WEST SUSSEX COUNTY COUNCIL CONSULTATION

TO:	Arun District Council FAO: Mr S Davis
FROM:	Highways, WSCC
DATE:	18/07/2018
LOCATION:	Land west of Fontwell Avenue, 1 Fontwell Avenue, Eastergate PO20 3RU
SUBJECT:	AL/136/17/PL Erection of pair of semi-detached houses & new access onto A29 - This is a Departure from the Development Plan
DATE OF SITE VISIT:	n/a
RECOMMENDATION:	☒ Advice ☐ Objection ☐ Modification ☐ No Objection ☐ More Information ☐ Refusal
S106 CONTRIBUTION TOTAL:	n/a

Scale	1:250	Drawn By	SMO	Checked By	ALB	Approved By	PMR
Date	July 2018	Drawing No.	2018-4370-001	Rev.	-

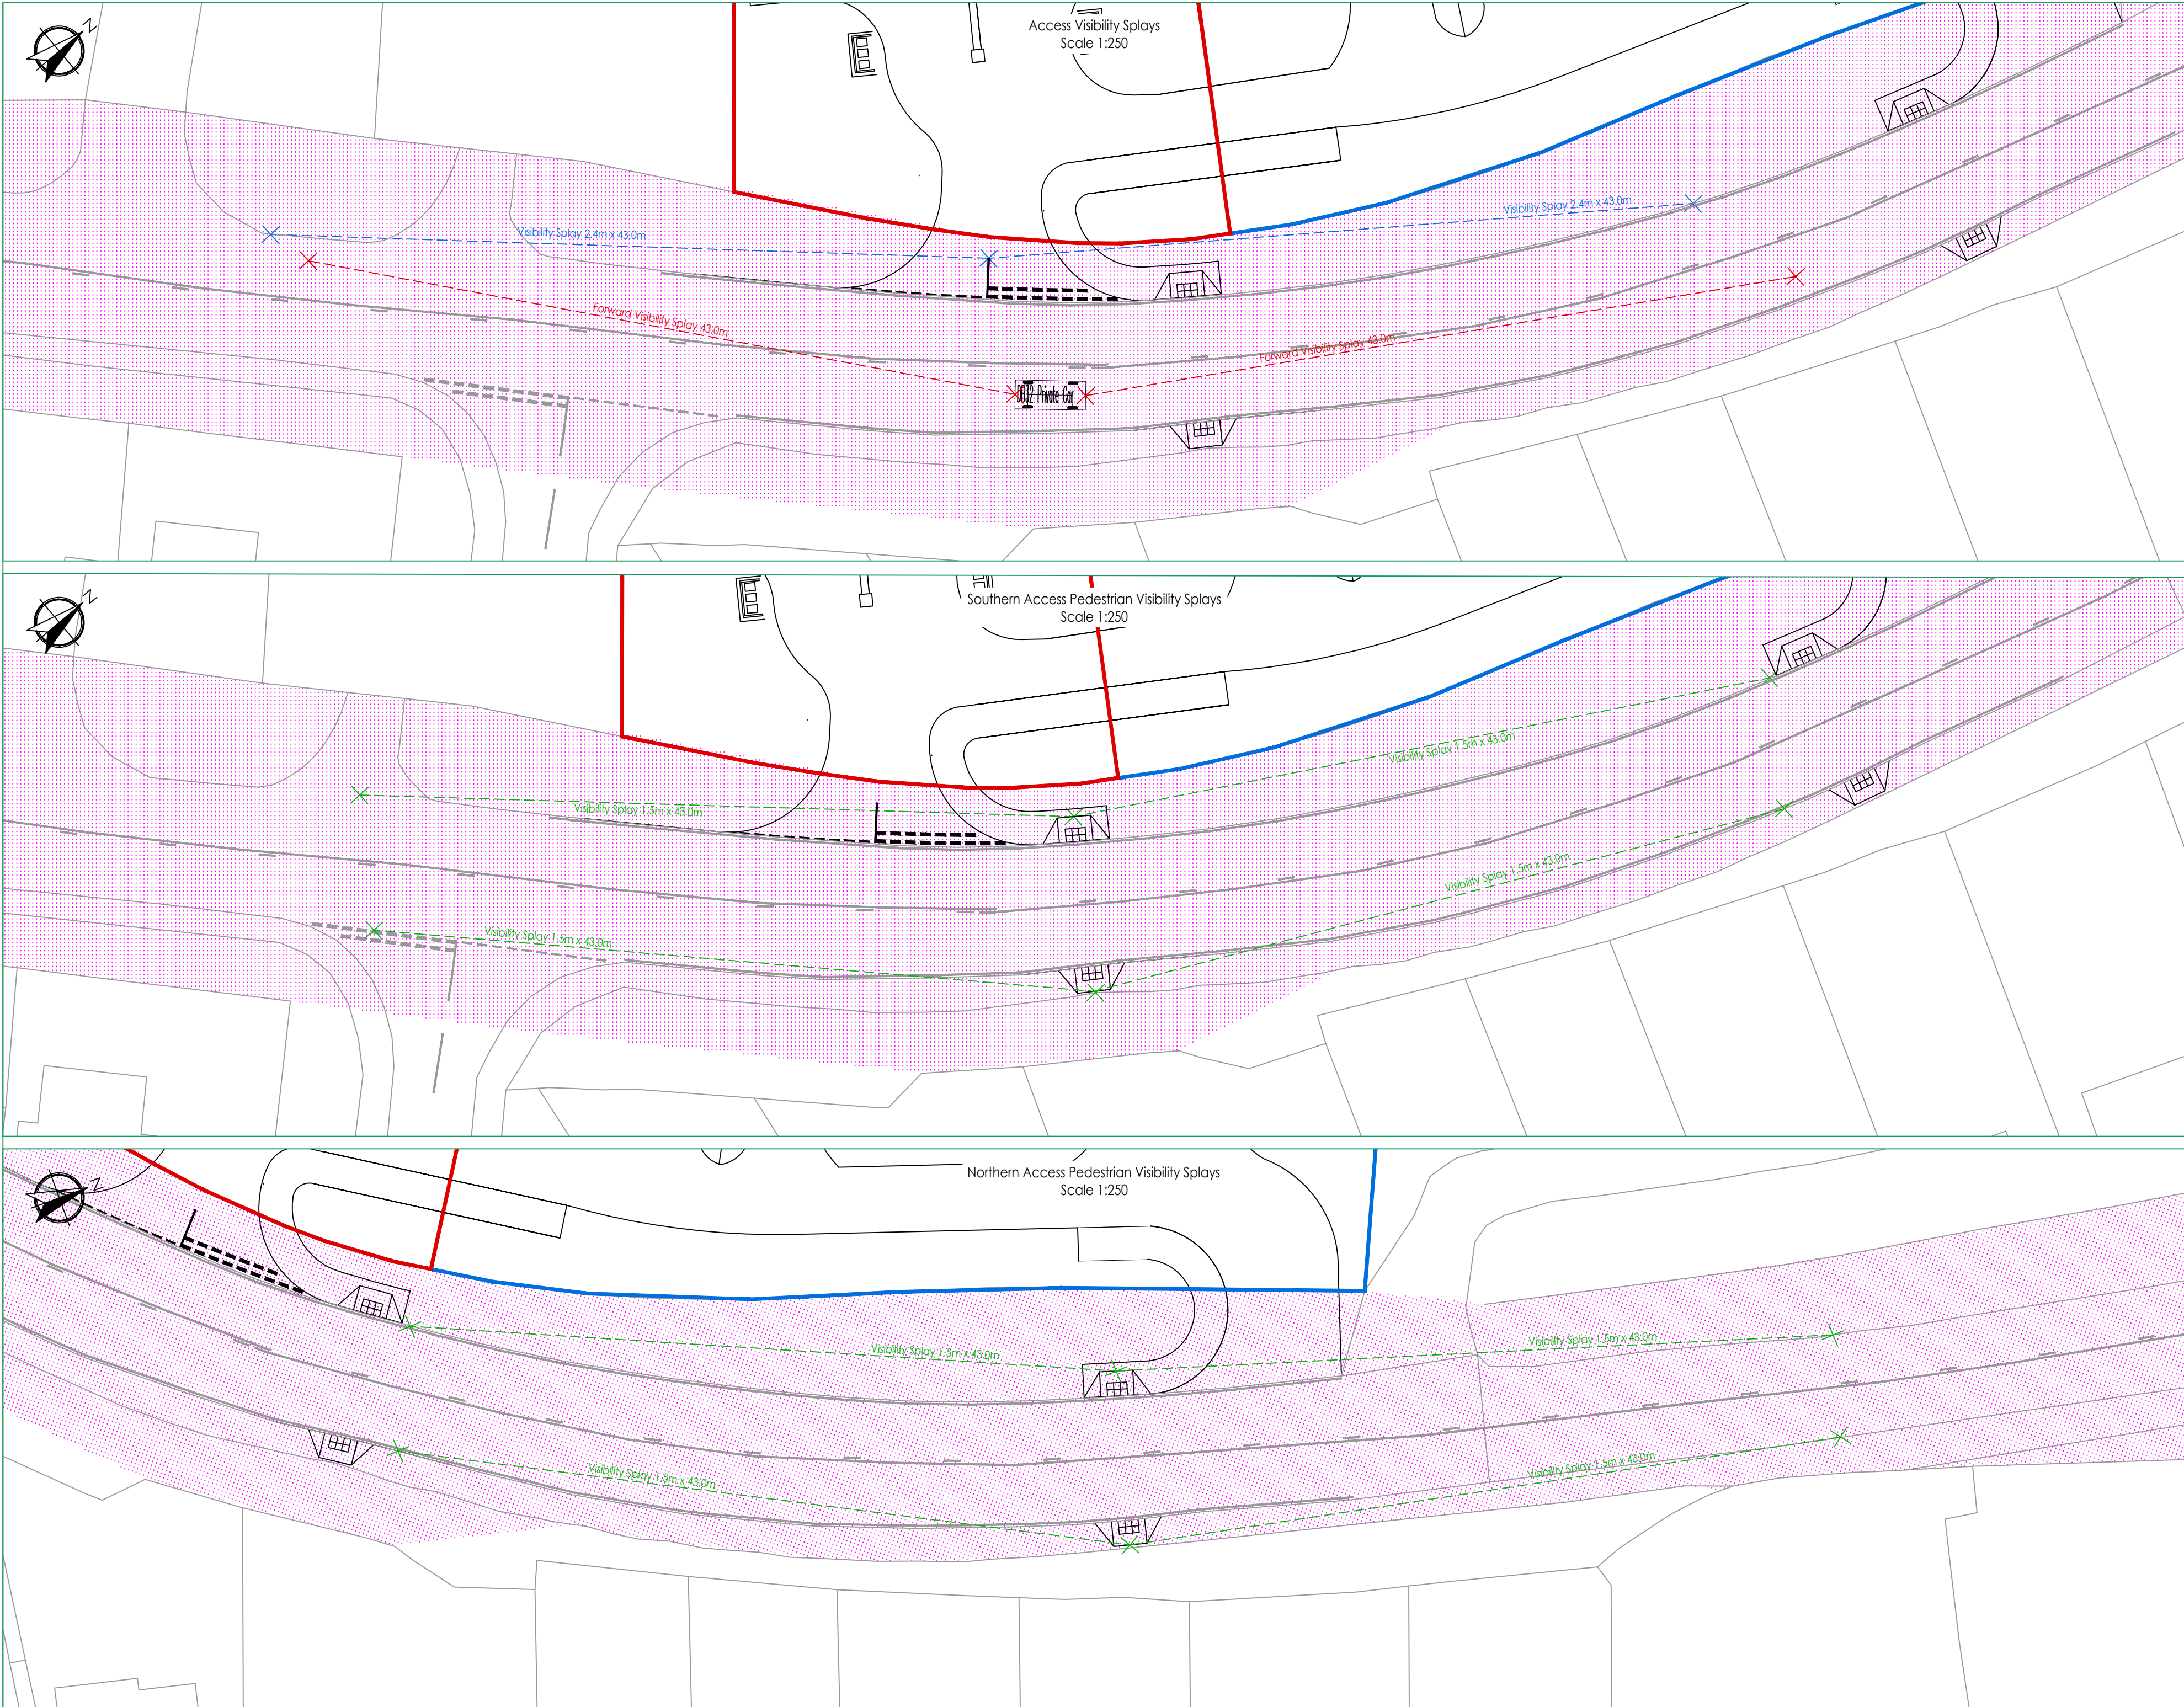
Plan 2018-4370-001 demonstrates a 2.4 x 43 metre visibility splay in each direction of the proposed point of access. Such a splay is considered appropriate with regard for the posted speed limit of the road (30 mph) as per guidance within Manual for Streets.

It has previously been accepted by the Local Highway Authority that historic speed survey evidence of 37.8 mph would require visibility splays of 2.4 x 59 metres as per using Manual for Streets Stopping Sight Distance calculation coefficients.

Plan 2018-4370-001 demonstrates a 2.4 x 43 metre visibility splay in this direction. While this is in accordance with the current posted speed limit is below the requirements previously considered acceptable using 85th percentile recoded road speeds.

I'm mindful that this historic speed survey data was collected when the speed limit for the site frontage was 40 mph; this has subsequently been reduced to 30 mph. However with the absence of any more recent actual road speed data I'm minded to require visibility be in accordance with these previously recoded road speeds.

Using the latest submitted plan it is however possible to plot a 2.4 x 59 metre splay, however there would be a requirement to use land outside the red edge to provide such a splay. This land is etched in blue on plan 2018-4370-001 and therefore it is not unreasonable that the applicant could secure this land to provide adequate visibility splays by way of planning condition. The Local Planning Authority is advised that this would require an amendment the red edge plans submitted.

Plan 2018-4370-001 demonstrates a 2.4 x 43 metre visibility splay in this direction. While this is in accordance with the current posted speed limit is below the requirements previously considered acceptable using 85th percentile recoded road speeds.

However using WSCC mapping and the plans provided it has previously been ascertained that visibility splays in excess of 2.4 x 150 metres is achievable wholly using land considered public highway.

This is significantly in excess of the splays required for the posted speed limit of the road 30 mph (2.4 x 43 metres as per Manual for Streets Table 7.1). This is also significantly in excess of splays that would be required for the demonstrated 85th percentile vehicle speeds for this direction when AL/95/13 was being considered. At this time the recorded 85th percentile road speeds were 38 mph which would equate to splays of 61 metres as per the Manual for Streets Stopping Sight Distance calculation parameters.

The latest plan (2018-4370-001) demonstrates a dropped crossing footway provision to enable a pedestrian link from the site onto the existing provision on the eastern side of A29.

Appropriate visibility splays at these crossing points have been demonstrated for the posted speed limit of the road. From these plans I am able to ascertain that appropriate visibility splays for the previously recorded 85th percentile road speeds are also available wholly using land considered public highway.

On balance the Local Highways Authority is satisfied that 'in principle' appropriate visibility splays can be secured in this direction.

In conclusion no highways concerns would be raised to the available southern visibility at the new point of access.

No part of the development shall be first occupied until minimum visibility splays of 2.4 x 59 metres have been provided at the proposed site vehicular access onto Fontwell Avenue in accordance with plans and details submitted to and approved in writing by the Local Planning Authority. Once provided the splays shall thereafter be maintained and
